Newark and Sherwood District Council (IP20049649)

12 November 2024

Deadline 2: Comments to the Examining Authority’s initial written questions (ExQ1) – schedule of responses

Figure 8.4 Planting for Loss of Local Wildlife Site Habitats

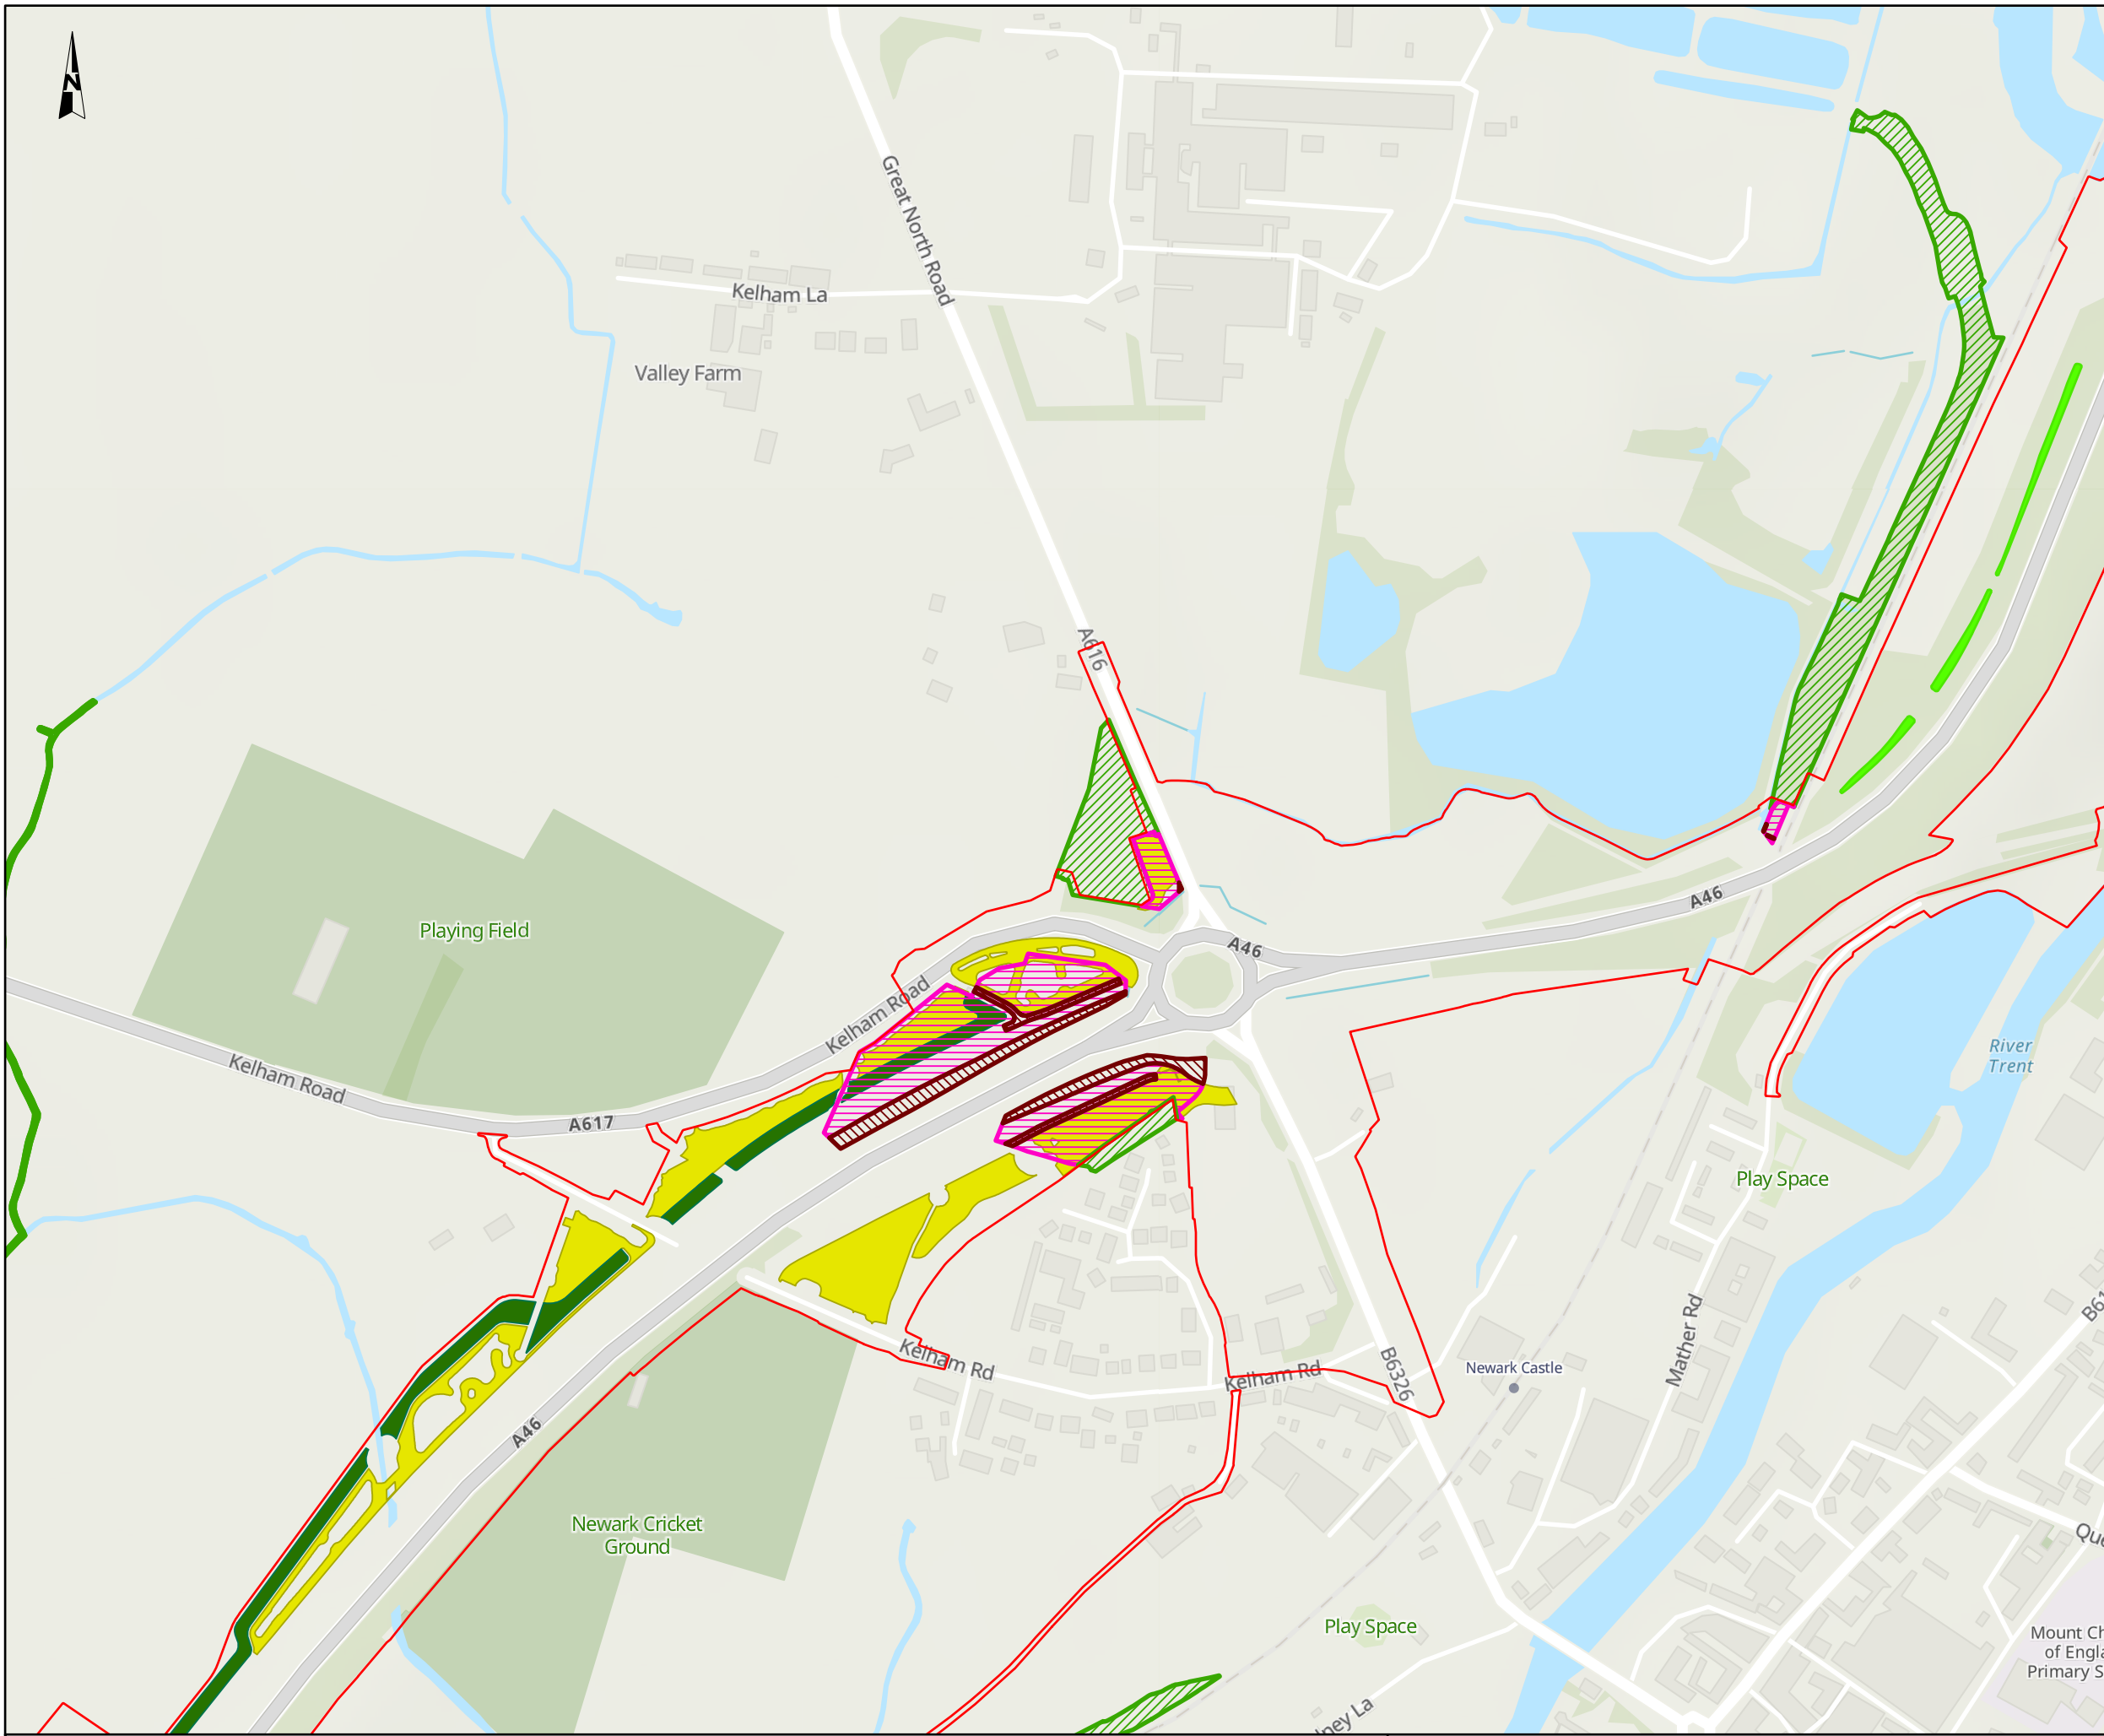
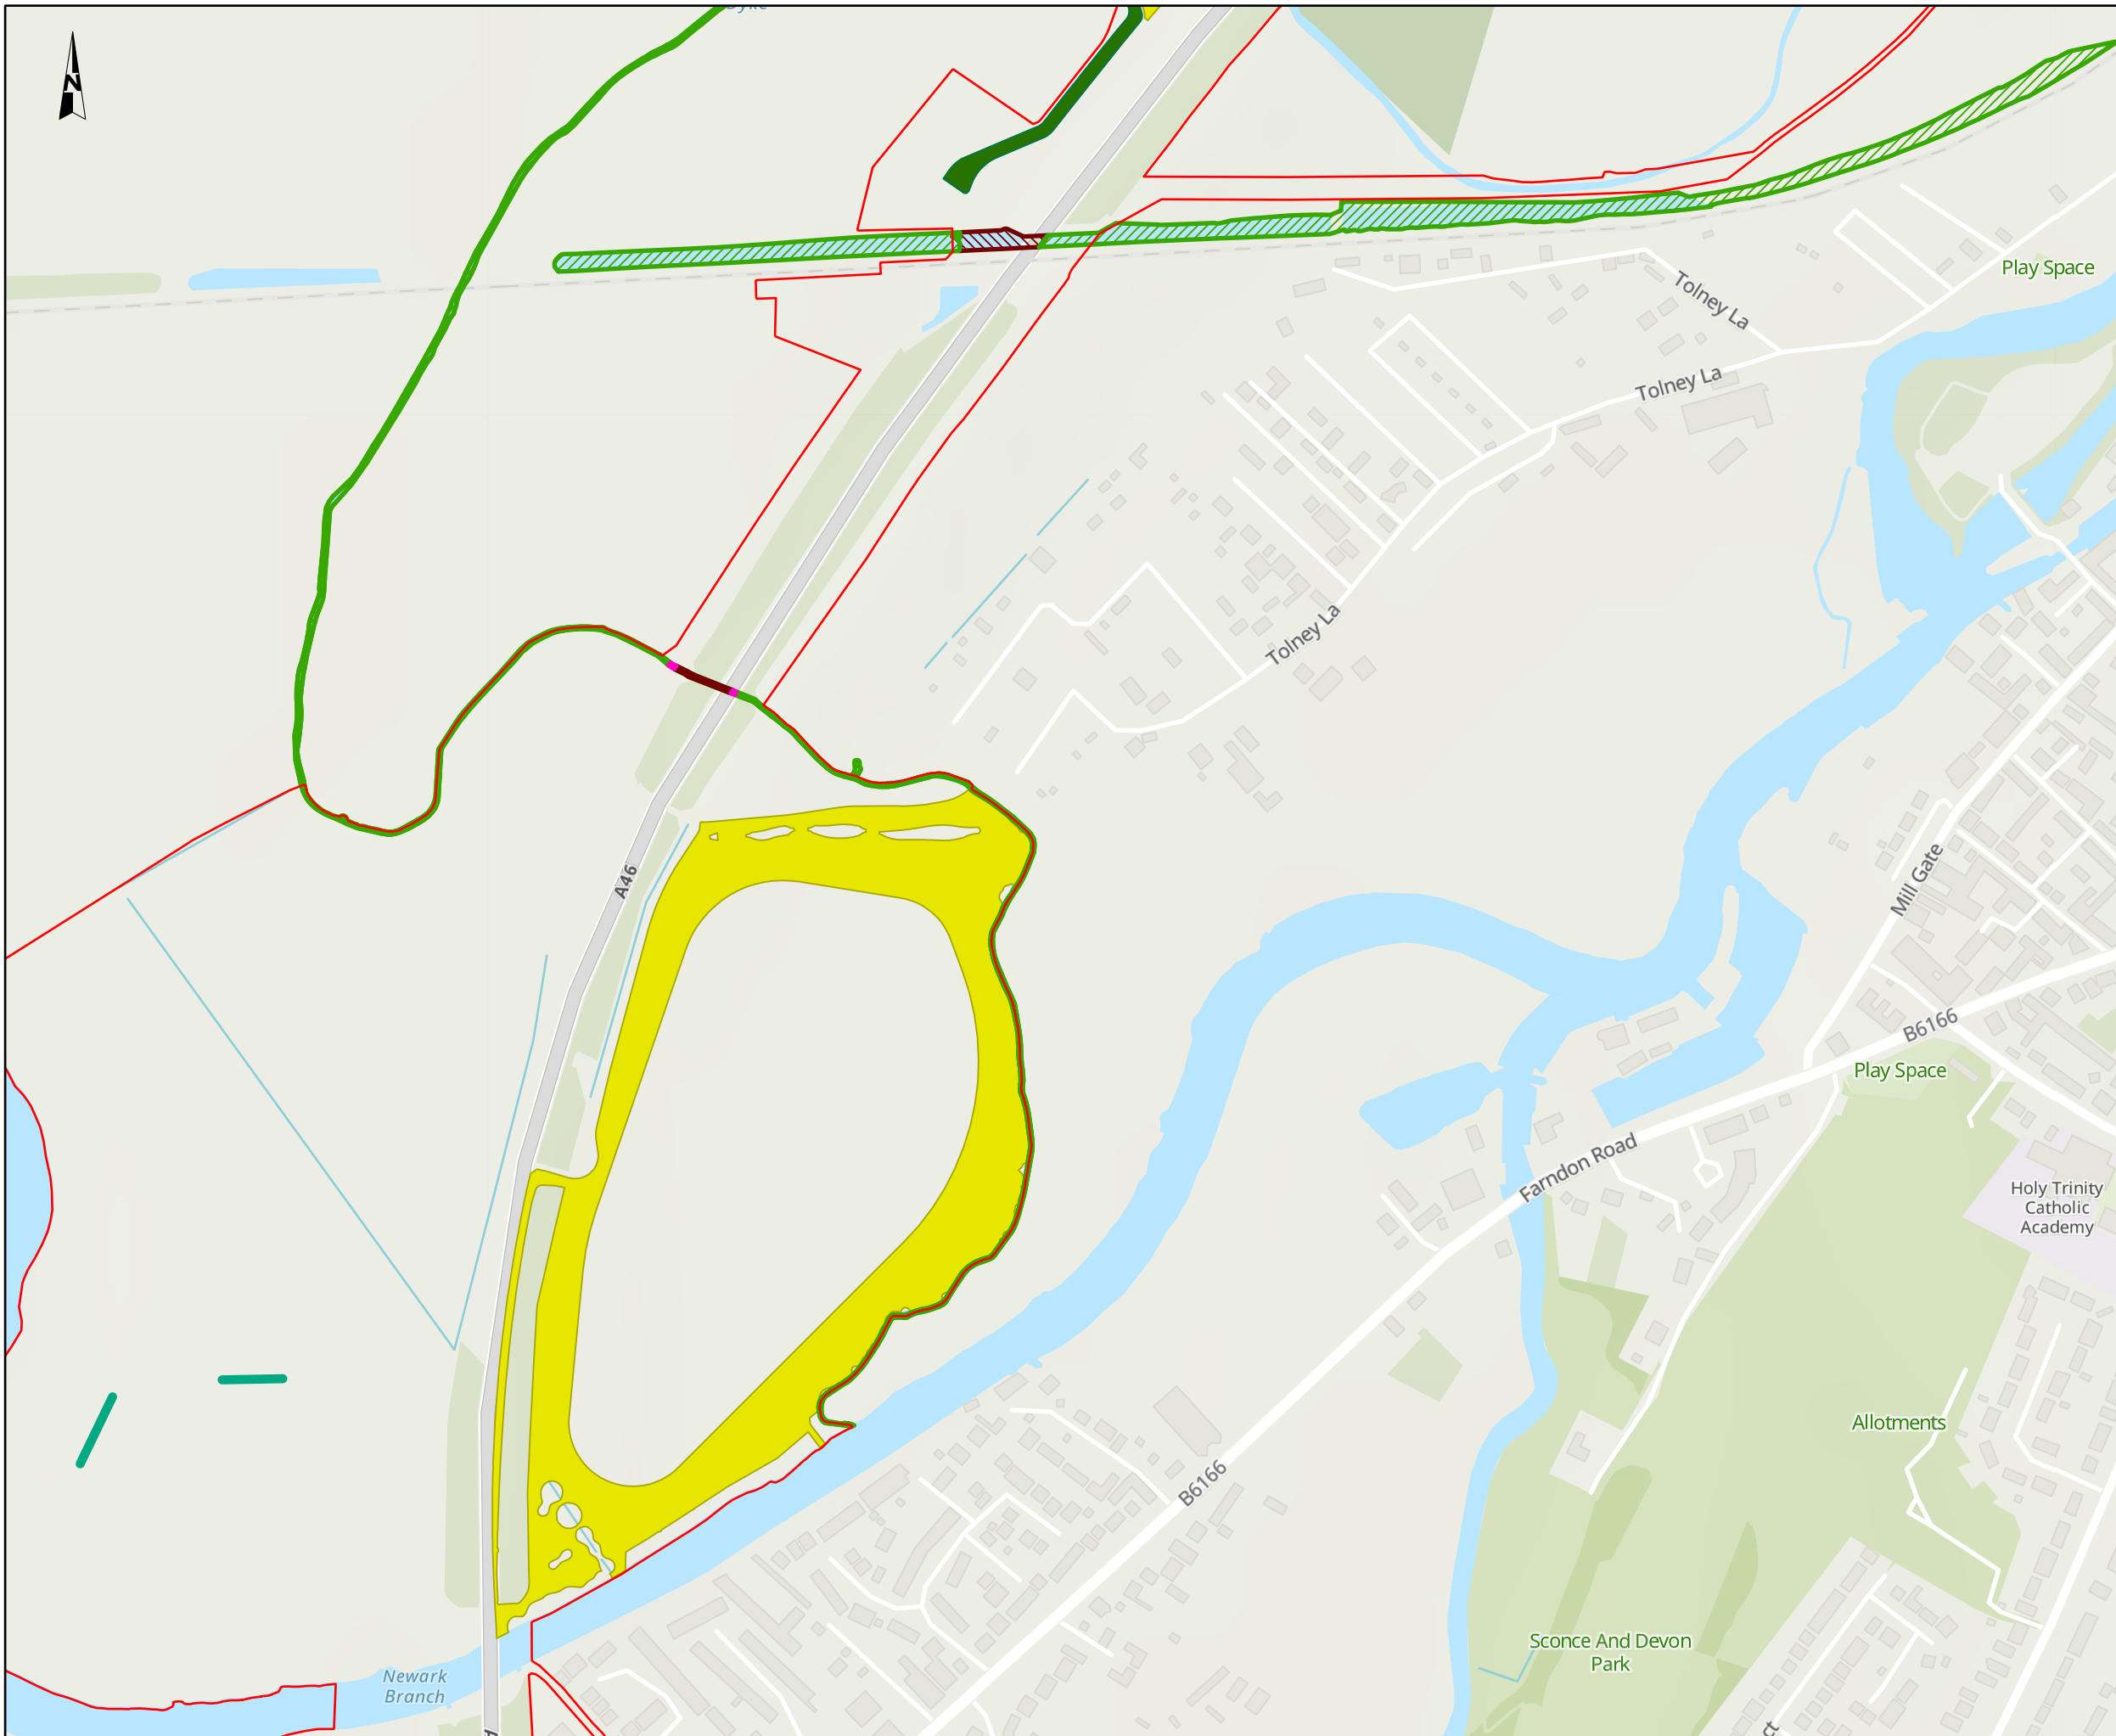
Q3.0.6	NSDC	<p>Local Wildlife Sites ES Chapter 8 [APP-052] provides a commentary on the impacts on four Local Wildlife Sites – Dairy Farm Railway Strip, Great North Road Grassland, Newark (Beet Factory) Dismantled Railway and Old Trent Dyke. Does the Council agree with the Applicant’s assessment and conclusions.</p>	<p>For sites at a higher level in the nature conservation designation hierarchy, guidance is that an effect is significant if it is likely to undermine the conservation objectives for that site (IAQM, 2020. A guide to the assessment of air quality impacts on designated nature conservation sites). Non-statutory Local Wildlife Sites do not have published conservation objectives making assessment of air quality impacts problematic. The methodology used has considered whether increased nitrogen deposition levels would affect the integrity of LWSs that have been designated for their botanical interest. NSDC consider that if a site degraded because of air pollution to the extent that it no longer met the relevant LWS selection criteria, that would clearly be a significant effect as continued qualification as a LWS would invariably be a conservation objective for that site. To have assessed air quality impacts on that basis would have aligned more closely with IAQM guidance. However, this would not have resulted in a conclusion whereby residual effects would have been of a higher level of adversity than has been concluded, so whilst we might have different view regarding the assessment method for air quality impacts on LWS, we agree with the conclusions.</p> <p>1.Dairy Farm Railway Strip:</p> <p>Para. 8.9.4 of ES Chapter 8 [APP-052] notes that loss of habitats includes arable habitats, but when the LWS boundary is viewed with an aerial image backdrop this doesn’t appear to encompass any arable habitat. On the assumption that this area is relatively small, NSDC do not consider that clarification is likely to alter the assessment conclusion for this site which we otherwise agree with.</p>

<u>Question No.</u>	<u>Question To</u>	<u>Question</u>	<u>NSDC Response</u>
			<p>2. Great North Road Grassland: NSDC are aware that following the most recent update (autumn 2024) of the LWS layers held by Nottinghamshire Biological and Geological Record Centre that the boundary of that part of this LWS that is located south of the A46 has been amended since the desk study was undertaken. We believe that the boundary has been redrawn to exclude hardstanding areas along the southern and eastern part of this section of the LWS. This would alter the assessed impact on the LWS in terms of percentage of the LWS area as set out in para. 8.9.5 of ES Chapter 8, but on the assumption that this has only affected areas of hardstanding that have no biodiversity value, this should not affect the overall conclusions for this LWS, which NSDC agree with.</p> <p>3. Newark (Beet Factory) Dismantled Railway NSDC agree with the assessment and conclusions for this LWS.</p> <p>4. Old Trent Dyke The assessment of impacts on this LWS have been considered in terms of linear length. Whilst the likely reasons for this (i.e., it is a linear habitat and is treated within the Biodiversity Metric as such), expressing potential effects in terms on linear meterage is considered by NSDC to have the potential to be misleading. The designation includes the full width of the channel, any marginal habitat and associated riparian habitat, so an assessment based on area rather than linear length should be used. However, in this instance, based on the average width of the designated LWS boundary being circa. 3m the total area of LWS that would be lost to the culvert would be 120m², which represents circa. 1% of the total area of the LWS. Therefore, notwithstanding this comment, NSDC agree with the overall conclusions for this site.</p> <p>The areas lost are not considered to be significant enough to adversely impact each LWS and their designated habitats, however no assessment on the connectivity these LWS provide and the impact the fragmentation of these LWS habitats during the construction has been provided.</p> <p>The proposals will result in a loss of 74% of the Great North Road Grasslands LWS and even with the compensation measures proposed will result in a moderate adverse effect significant at the county level. No explanation to why the proposals will impact the majority of this significant area of LWS grassland has been provided. The post development habitats include the creation of lowland meadow grassland and species rich grassland and not the retention and improvement of the existing LWS grasslands. Further justification for the level of habitat loss in this area will need to be provided as not all of the area is required for the proposed SUDS and carriageway widening. It is likely that the LWS status will be lost as part of the proposals.</p> <p>It should also be noted that lowland meadow is not defined as an irreplaceable habitat, but is difficult to create and maintain. Areas proposed for lowland meadow creation may not be feasible due to soil composition and management requirements.</p>
